The Former Ship Inn, Aldwick Street, Bognor
Proposed One Stop Store
Applicants Response to Stage 1/2 Road Safety Audit For One Stop Stores

Applicants Response to Stage 1/2 Road Safety Audit For One Stop Stores

Tracking Plan : Option 3
scale 1:500 @ A1

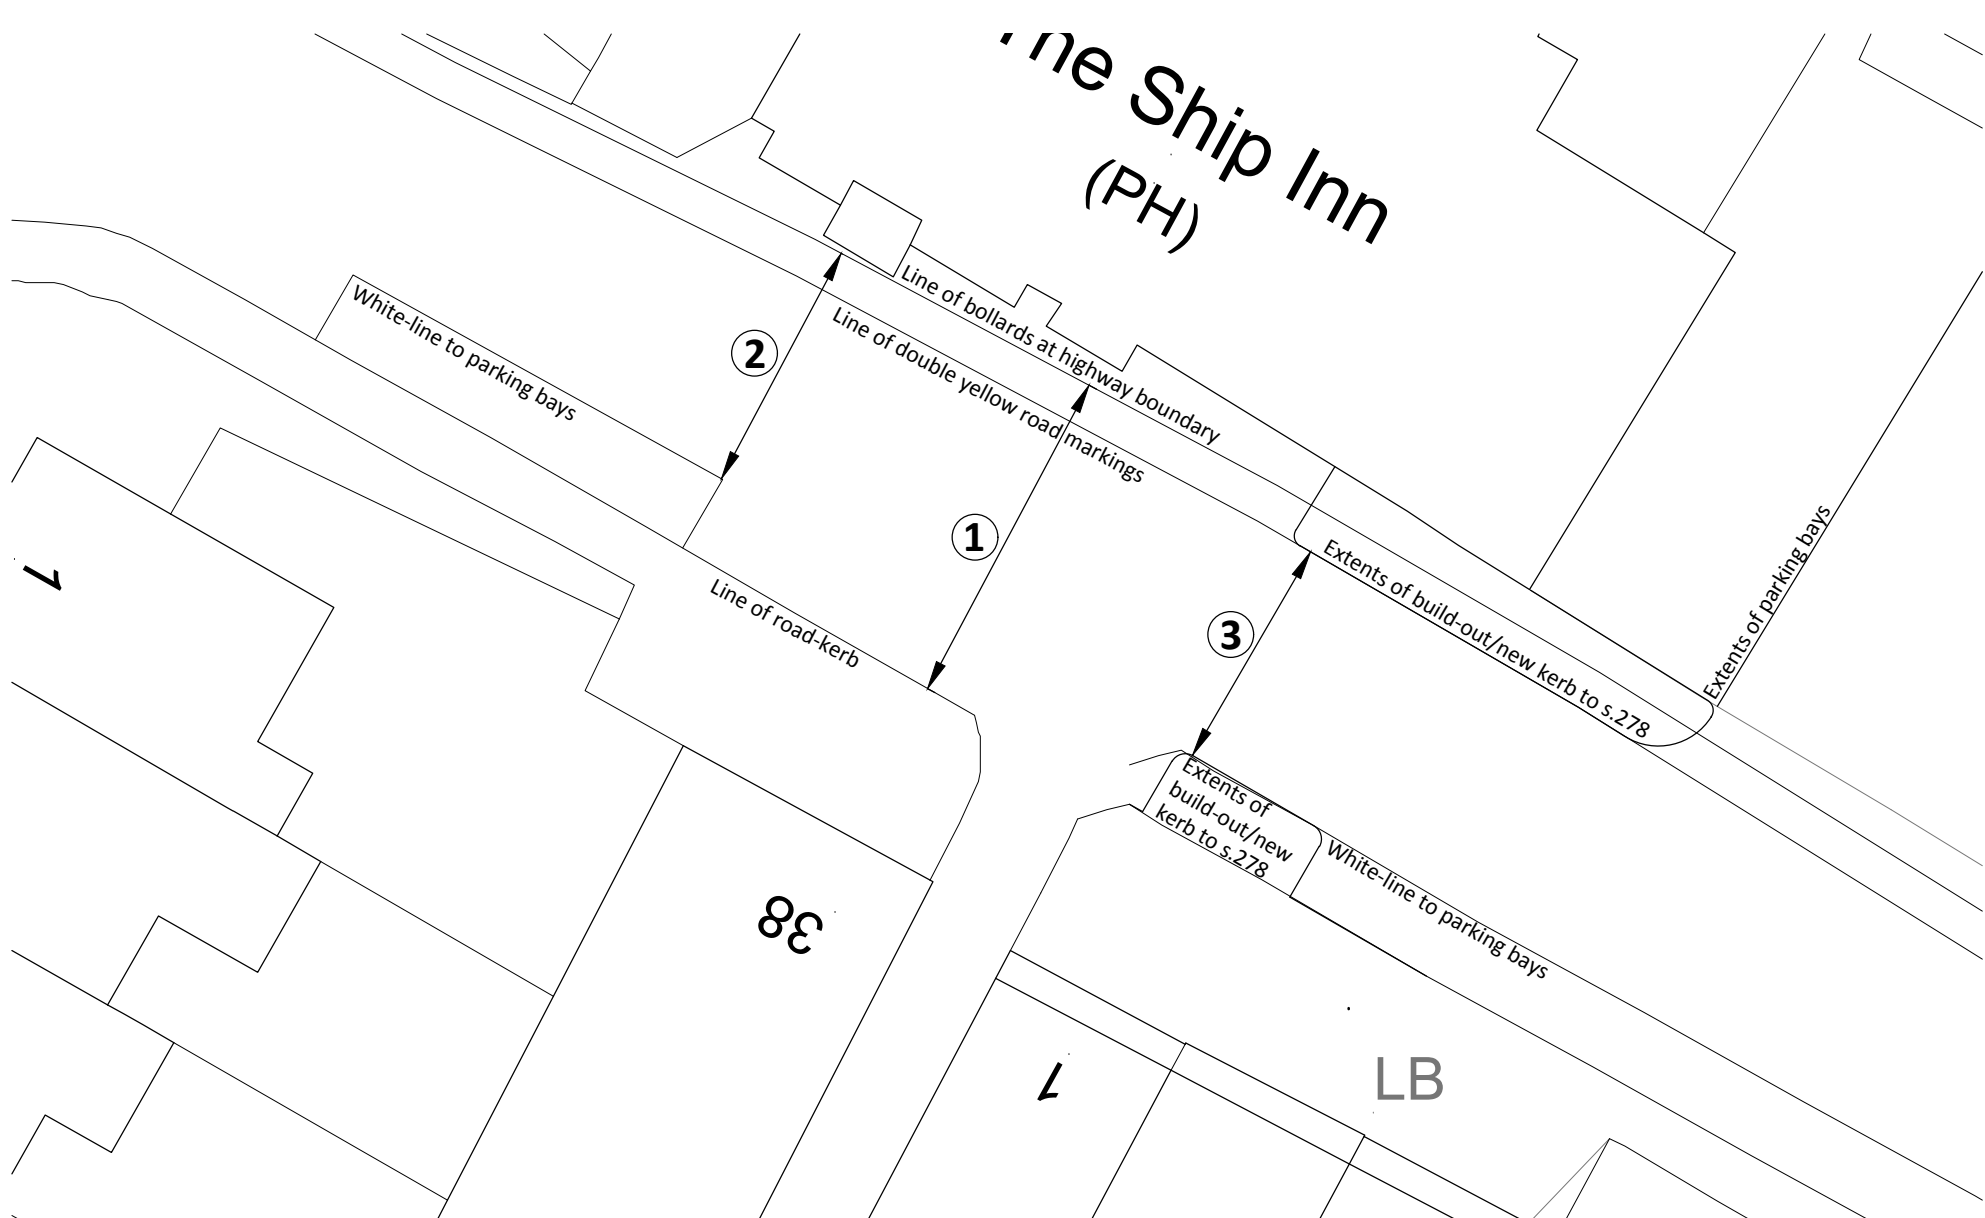
Item No.	Audit Team Recommendations	Applicants Response
5.1	Carriageway levels should be reviewed and drainage provided at the proposed buildouts as necessary.	We have not been involved with the design of the build out proposals. These designs have been previously issued to WSCC, and subsequently approved as the desired construction details in agreement with WSCC as part of the s.278. If additional further drainage is deemed necessary, then by agreement with WSCC, a drainage channel could be incorporated to maintain the kerbside drainage channel continuity, unless another reasonable solution can be suggested, if needed or warranted by WSCC. However, it is reiterated that these details are previously approved.

Item No.	Audit Team Recommendations	Applicants Response
5.5	Pedestrian routes approaching the store should be formalised.	A pedestrian crossing point to the highway will be provided as part of the s.278 proposals. This is with the build-out, which is shown on all tracking plan drawings.
5.6	No issues raised.	n/a
